NAPA, 235 Presumpscot St

From: Christina Stacey [mailto:cstacey@portlandmaine.gov]
Sent: Friday, October 28, 2016 1:50 PM
To: Diana Olmstead <di@neokraft.com>
Subject: NAPA, 235 Presumpscot St

I am looking at the sign permit application for NAPA but there are few questions.

**DOUBLE FACE INT. ILLUM. MONUMENT SIGN —32 SQ. FT.**

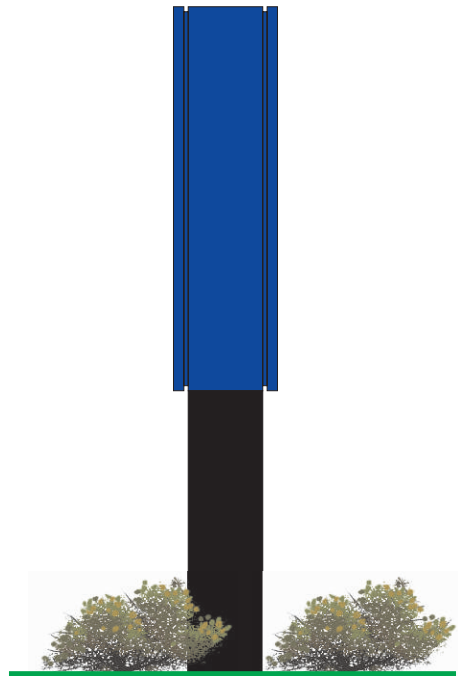
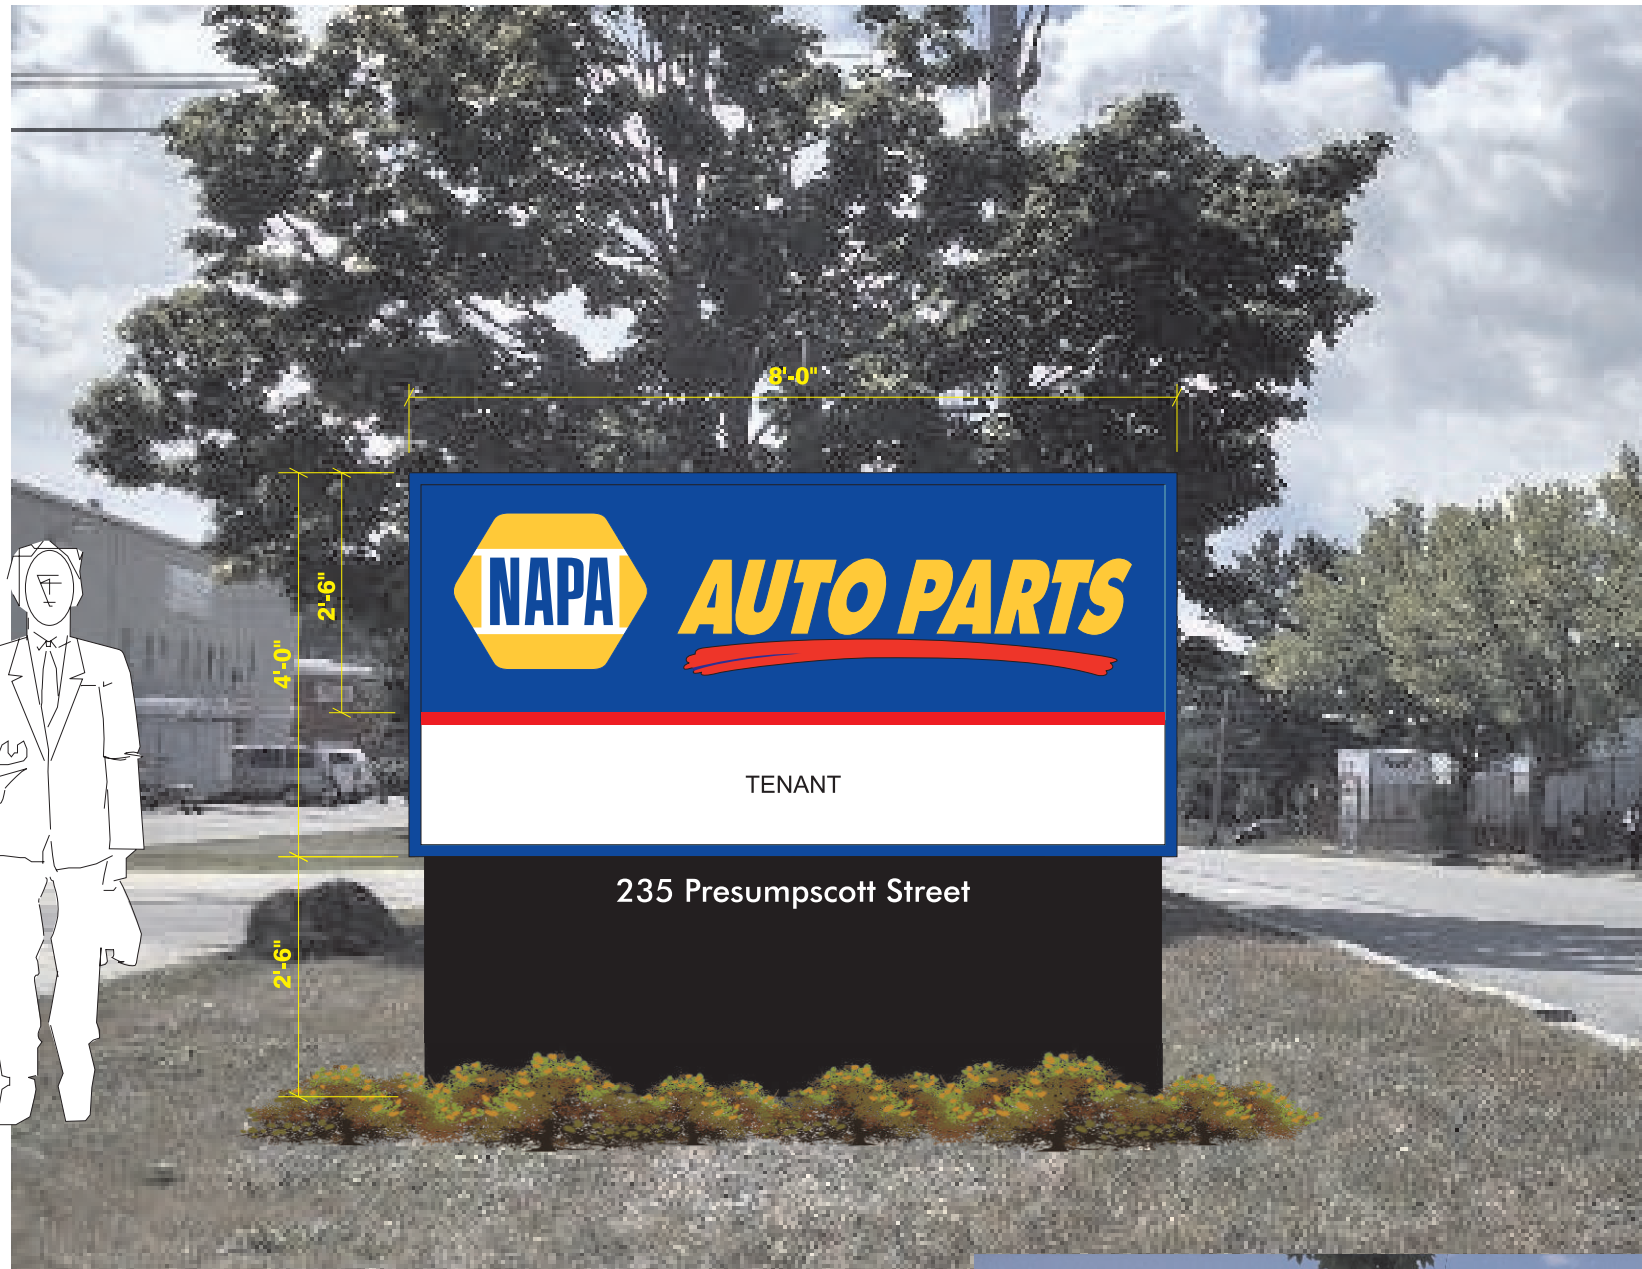
First, this is located in the I-M Industrial zone and is a multi-tenant lot. A multi-tenant lot can have only one free-standing sign that should be jointly shared between tenants. According to Google Street View, it appears that there is or was an existing free-standing sign for a storage company. Is that sign still in place? If so, we can't permit a second sign and would need the landlord to resolve this issue by offering a joint ID sign for everyone, or by removing the existing sign to allow the NAPA sign.

Second, if the NAPA monument sign will be the only free-standing sign on the lot, it needs to be set back 5 feet from the front property line. Can you confirm that the sign will be placed at least that far back?

1. The former sign by the road has been removed.
2. The building height is actually 25' with the sides being 85' long.
3. I'll downsize the side wall sign and re-submit.
4. The monument sign is set at 7' back. I wanted to clear visibility.

INT. ILLUM. EXTERIOR WALL ID

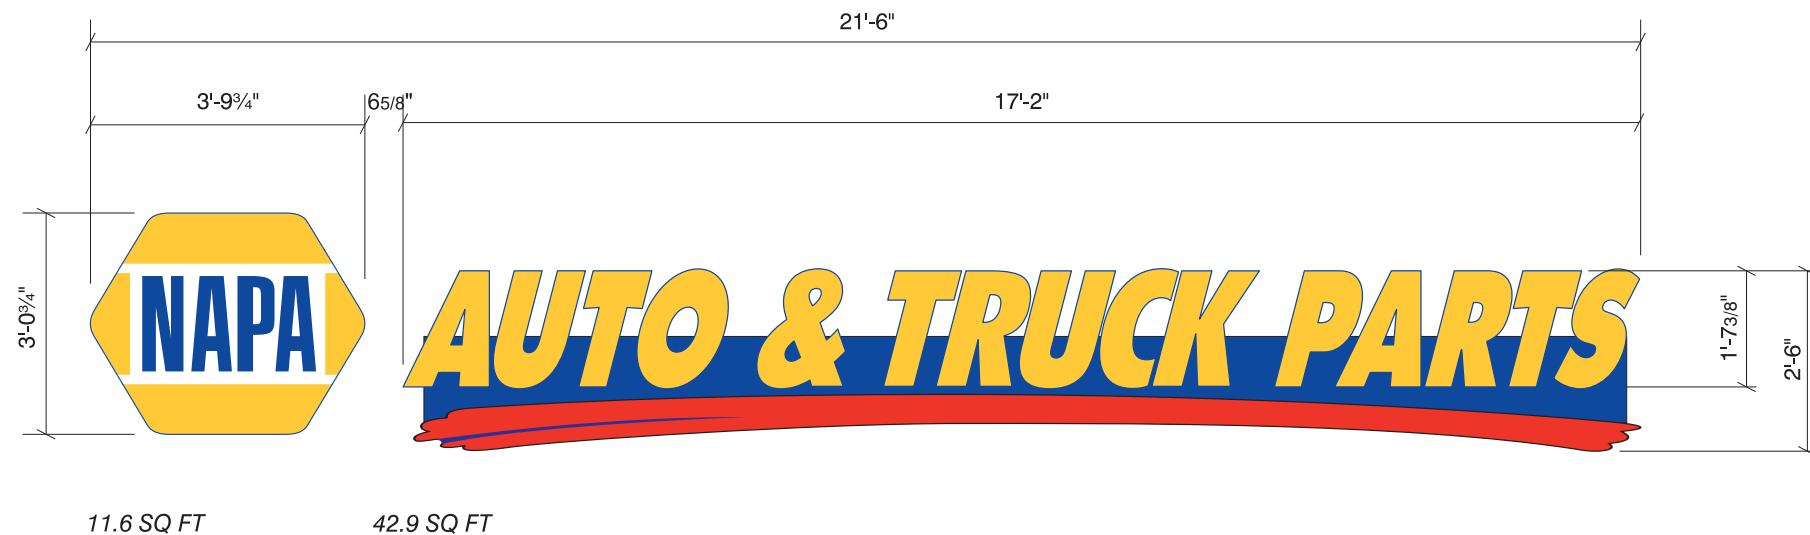
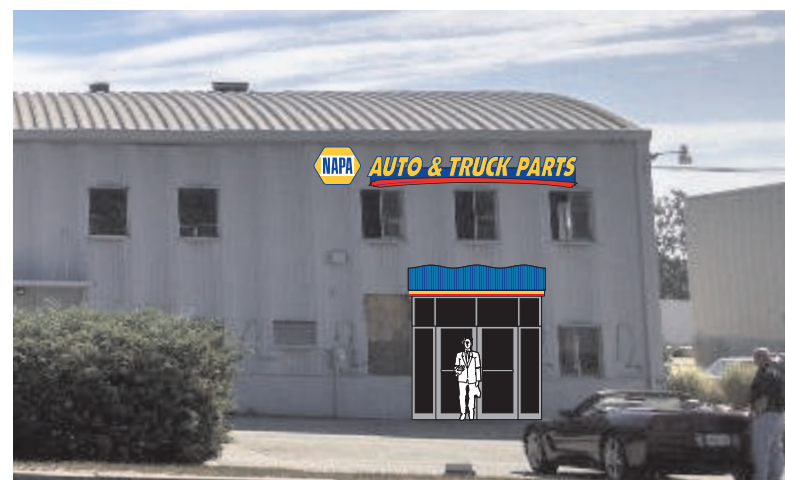
Finally, I think the signs on the sides of the building are too large to meet the ordinance. For a multi-tenant building, we allow one sign per tenant plus one additional sign per building face. The size limit for the principal facade is 8% of the

wall area, and for other facades is 2% of wall area. The actual wall area for these facades was not provided as part of the application, but I tried to guesstimate based on the Google Street view and tax assessor's records. There are no issues for the principal facade facing Presumpscot St, but the two other sides I estimate to be about 81' long by 20' high, for a total wall area of 1,620 sq ft. Calculating 2% gives a maximum size sign of about 32 sq ft, and NAPA is proposing signs of 54 sf.

If you can get a more accurate wall area I am happy to look at that, but if the side signs still exceed 2% they will have to be reduced in size to meet the requirement.
